Appendix A Submissions Register

Table 1 The Department Preliminary Assessment Comments

Table 2 Council Submission Comments

Figure 3 Case studies

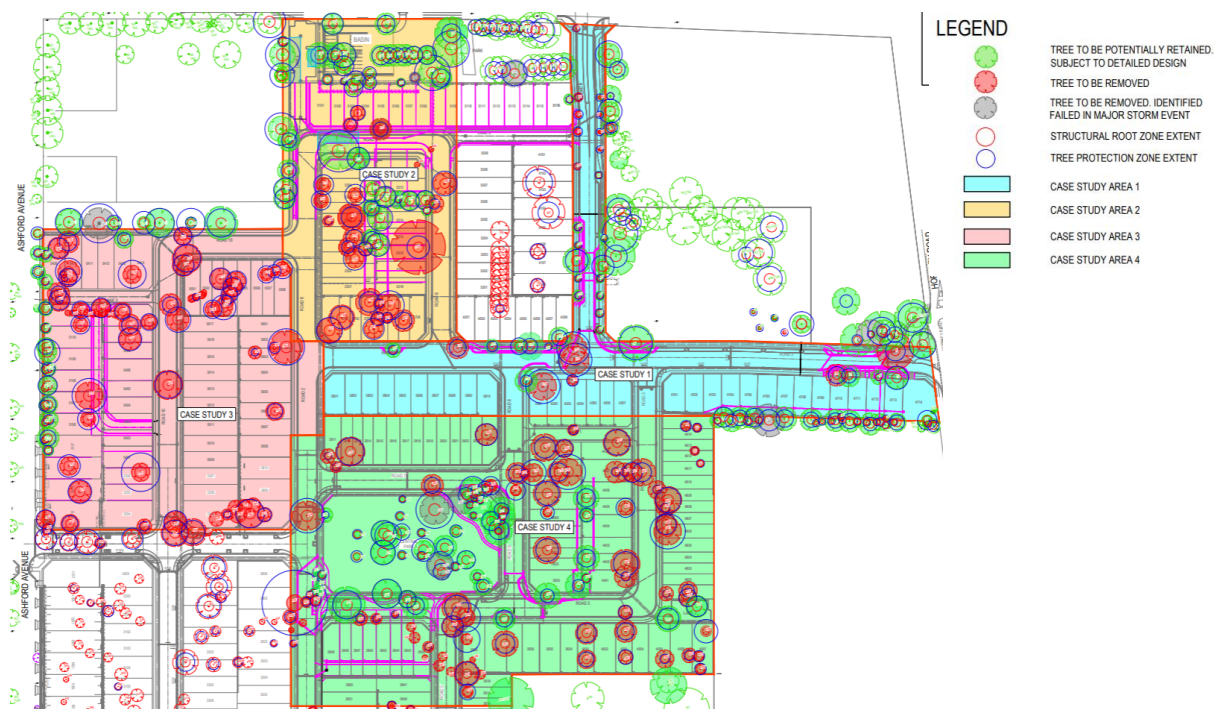
• It is clear from the plans provided that much of the vegetation proposed for removal could be retained under the current design and further design amendments could allow for the retention of further vegetation. These are considered avoidable impacts.	Section 7.2.3.1 of the BDAR (refer Appendix D) explains how Mirvac and SLR conducted monthly workshops over a period of six months with the engineering team to review the civil plan and project layout in order to retain as much native vegetation as possible within the subject land. A number of case studies were discussed in detail, with the objective of retaining additional vegetation, however in a workshop with Council (dated 18 June 2025), Council were not supportive of any of the proposed case studies.

Comment	Response
	The current design has been based off the structure plan under the DCP which was established under the Planning Proposal. The Planning Proposal took into account the future vegetation removal required to deliver the overarching project. In carrying out the detailed design, several areas of vegetation were able to be retained as a result of more bespoke approach to engineering matters such as road and stormwater drainage designs. As outlined in the BDAR at Appendix D , the vegetation removal proposed is necessary for the delivery of the proposed development, as envisioned by the site-specific DCP.
Landscape Plan The provenance of plant species and canopy cover as a percentage of site area have not been articulated in the Landscape Plan. Opportunities to retain significant trees have not been explored to inform the plan as per the requirements of the SEARs.	The provenance of plant species and canopy cover has been articulated in updated Landscape Plans at Appendix M .

Figure 7 | Ecological Communities (Source: Biodiveristy Development Assessment Report)

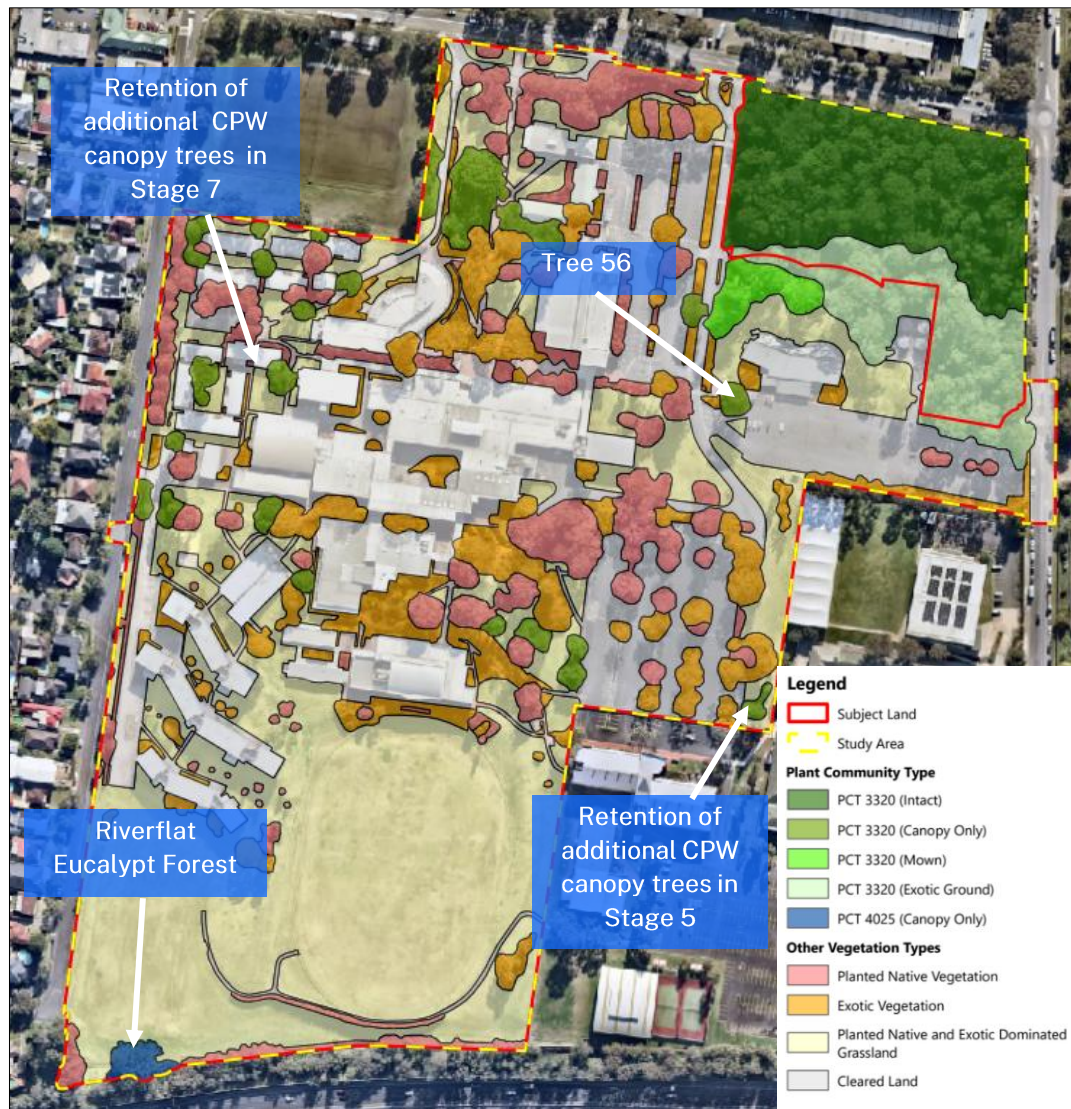
• Cumberland Plain Woodland must be retained within the proposed subdivision. This includes retaining Cumberland Plain Woodland within proposed lots, road corridors and recreational land. This currently has not been demonstrated and as such, reasonable avoidance in accordance with section 6.4 of the BC Act of impacts has not been demonstrated.	Please refer Section 7.2.2 and Figure 13 of the BDAR. CPW has been retained throughout the study area, particularly within the E1 zoned land and along the western boundary of the Milperra Reserve. SLR, Mirvac and the civil team conducted monthly workshops to determine whether additional CPW could be retained within the proposed subdivision, and solutions including the addition of kerb blisters and installation of a pedestrian link were proposed to Council. As these civil works variate from the LEP and DCP, they were not accepted (see Section 7.2.3.1 of BDAR).

• No genuine attempt has been made to retain vegetation within the proposed subdivision. Vegetation shown for retention within the RE1 – Public Recreation zone is limited to planted native vegetation and does not comprise Cumberland Plain Woodland. Accordingly, reasonable avoidance has not been demonstrated.	Chapter 7 of the BDAR discusses the avoidance in depth. Section 7.2.3.1 of the BDAR explains how Mirvac and SLR conducted monthly workshops over a period of six months with the engineering team to review the civil plan and project layout in order to retain as much native vegetation as possible within the subject land. A number of case studies were discussed in detail, with the objective of retaining additional vegetation, however in a workshop with Council (dated 18 June 2025), Council were not supportive of any of the proposed case studies. Although vegetation within the RE1-zoned land does not conform to CPW, effort has been made to retain as many trees as possible within these areas. The northern and central park areas contain a high density of planted native trees, which have a connected canopy and so is of higher biodiversity value than the scattered trees throughout the study area. Additionally, both of these areas contain multiple hollow-bearing trees (refer Figure 14 of the BDAR at Appendix D), which are an extremely important resource for threatened fauna. All vegetation within the E1 zoned land conforms to CPW and will be retained as part of the project.

• With the C2 zoned land excluded, the BDAR must then identify the areas of Cumberland Plain Woodland proposed for retention and removal.	Refer Figure 13 of the BDAR at Appendix D .
